Ann Machado - RE: 11 Ludlow Terrace

This responds to your e-mail to Candace SCRIPTURE at Custom Float Services requesting additional information regarding the dimensions of the home and lot for David P. HAYFORD and his wife Karen MILLS located at 11 Ludlow Terrace, Portland, Maine 04102. David has a disability and is eligible for our Critical Access Program to install a wheelchair ramp at their home.

Hayford, David M.
11 Ludlow Terrace, Portland, Maine 04102

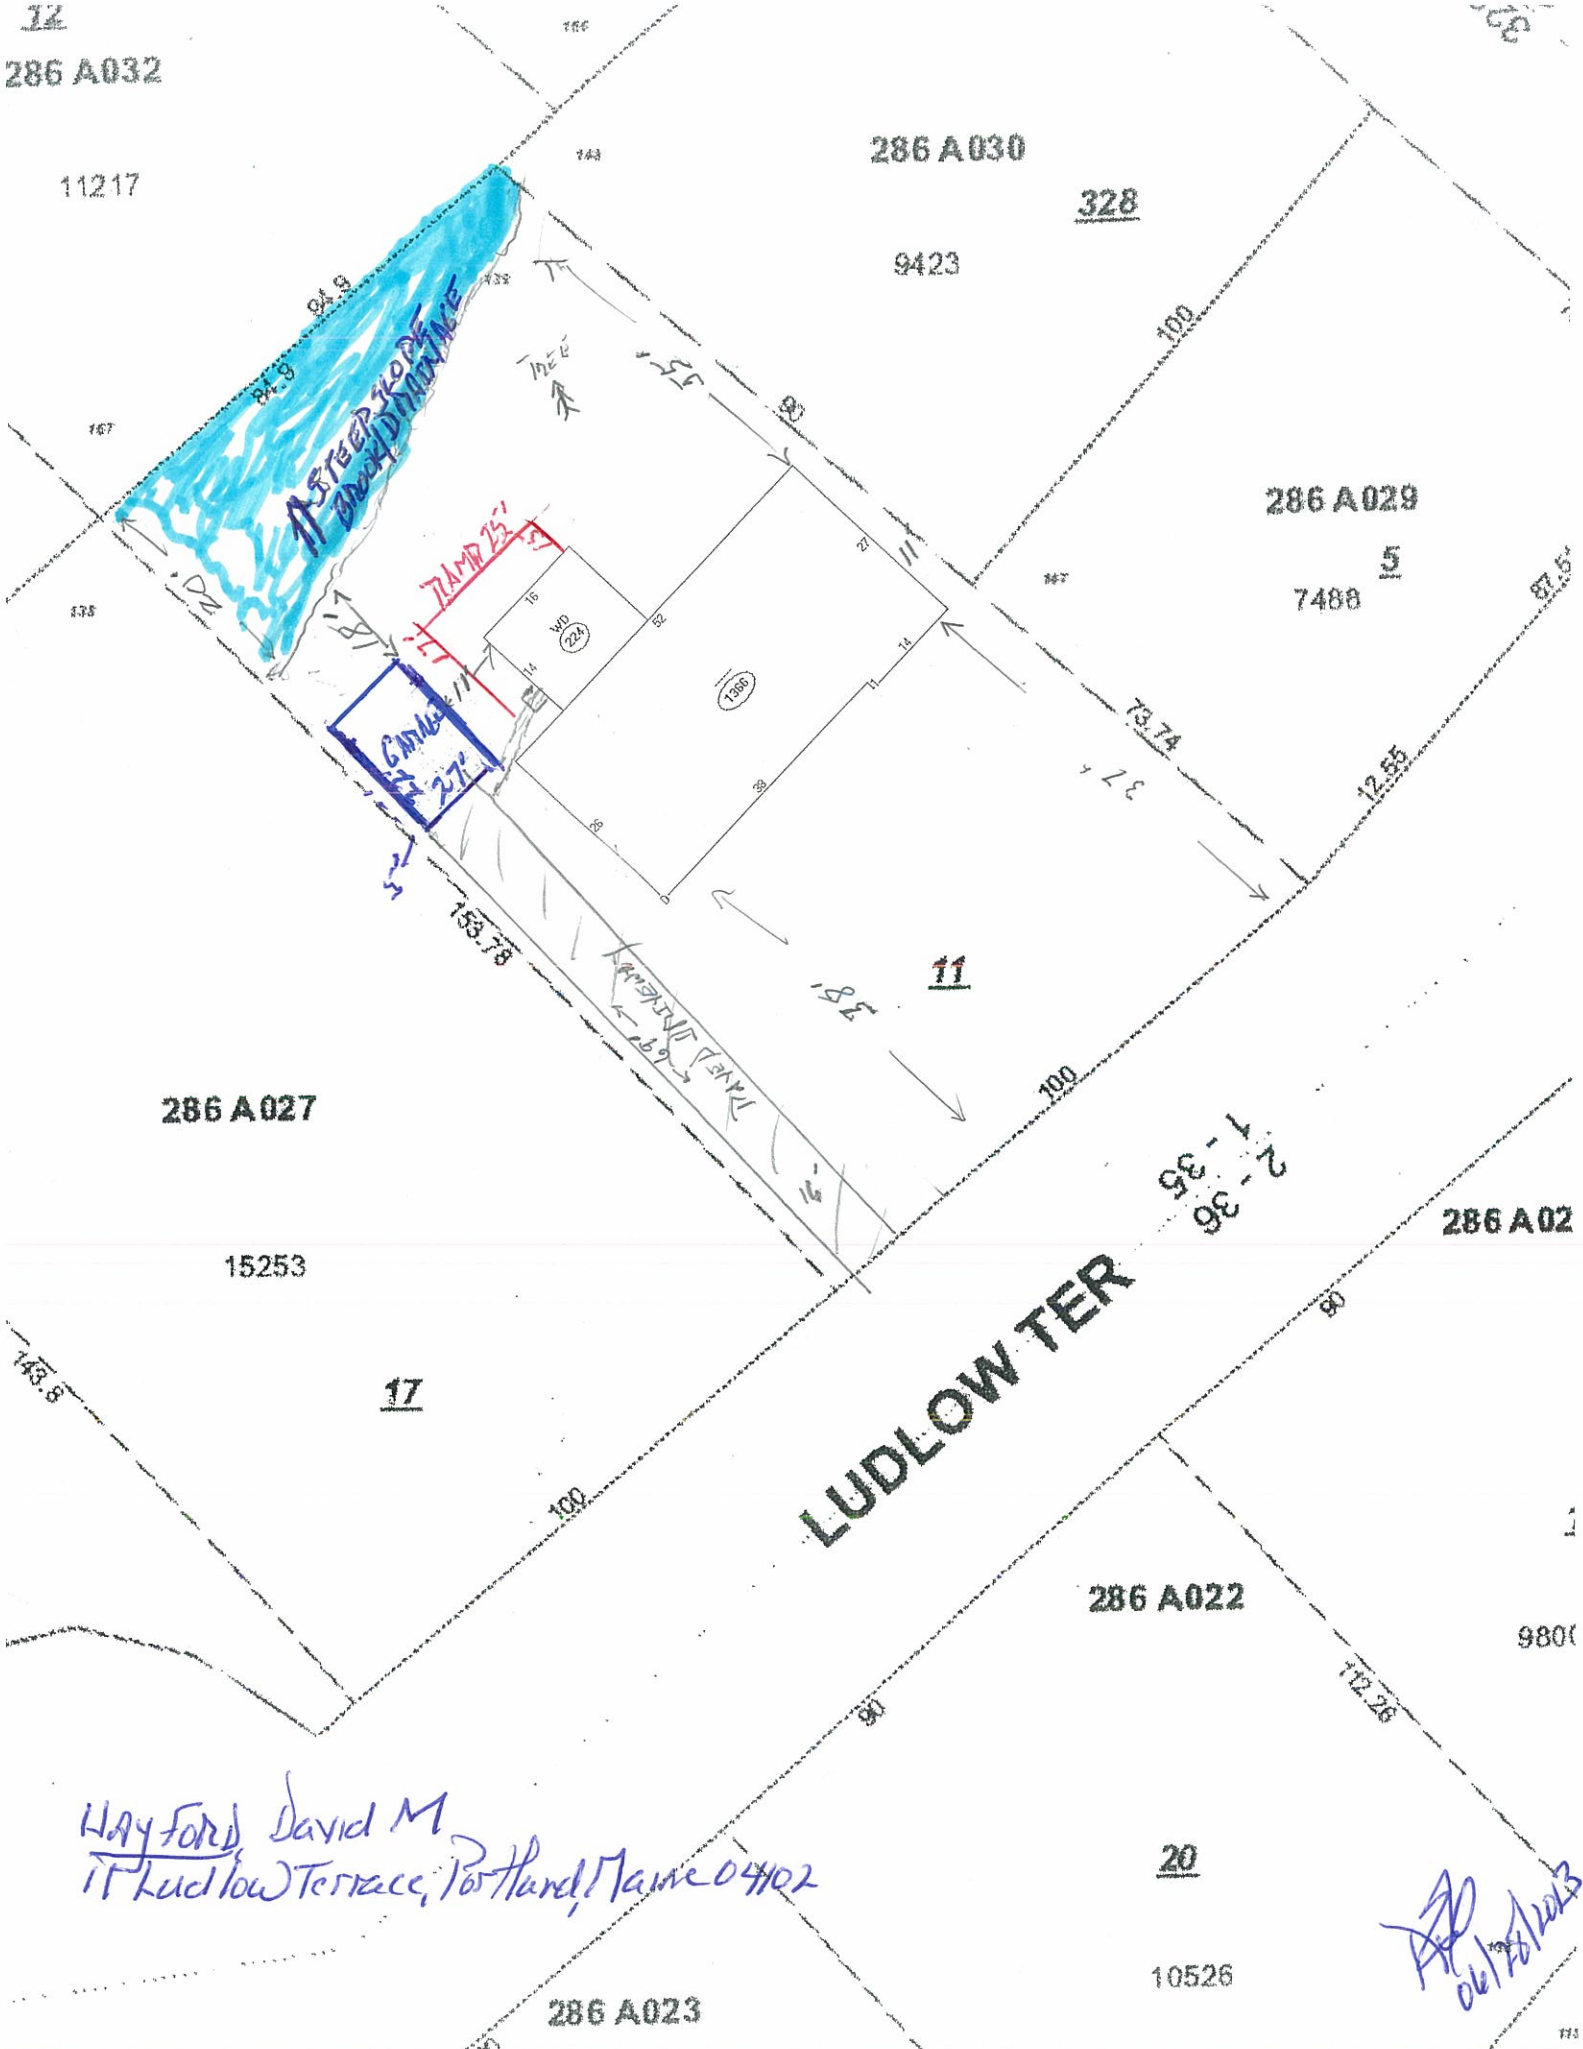
As far as the plot plan goes, it needs to reflect the shape of the whole lot with the dimensions of the lot and the footprint of what is existing and proposed with the setbacks to all the property lines. This should not be based on the GIS. The GIS is a reference but it is not an accurate rendition of what exists. Dwight can either use the shape of the lot from the tax map and then locate the structure on the lot with the setbacks or look at the dimensions of the lot based on the owners deed. What I originally said was that the lot is 153.78 feet deep so I'm sure that the ramp will twenty five rear setback but Dwight does not indicate this on the plot plan he submitted. He is showing C12' behind the garage to the rear property line and I don't think that this reflects the depth of the lot.

Attached is an additional plot plan of the site proposed for the ramp. As suggested, I superimposed the sketch of the home over the tax map found on the Portland Assessors website, "property lookup". Then I visited the site again and took additional measurements.

Unfortunately, I could not locate surveyor's "pins" marking the boundaries of the lot, particularly the rear property line. The tax map indicates the north side of the lot extends back 164 feet from the street, and the south side extends back 154 feet from the street. The back yard ends on a steep bank that slopes down to a brook or drainage ditch.

I carefully measured the distances from the street to each corner of the front of the house; 37 feet on the north corner, and 38 feet on the south corner. The width of the house recorded on the assessor's sketch is 27 and 26 feet respectively. The sketch also indicates the width of the deck on the back side of the house is 14 feet.

Adding these together, the ramp will begin 78 feet deep into the lot, and extend an additional 15 feet or 93 feet from the street. Using the dimensions on the lot from the tax map, the ramp will be 71 feet to 61 feet from the rear property line.

The lot does not look that deep to me, so I measured fences on the adjoining properties to better determine the rear property line. It is 55 feet from the rear northern corner of the house to a fence post along the bank. It is 18 feet from the rear corner of the garage to the top of the bank, and 20 feet down the bank to the end of the neighbor's fence. From these measurements the ramp will be at least 26 feet from the rear property line.

It will be 37 feet from the northern (side) property line, and 34 feet from the southern (side) property line.
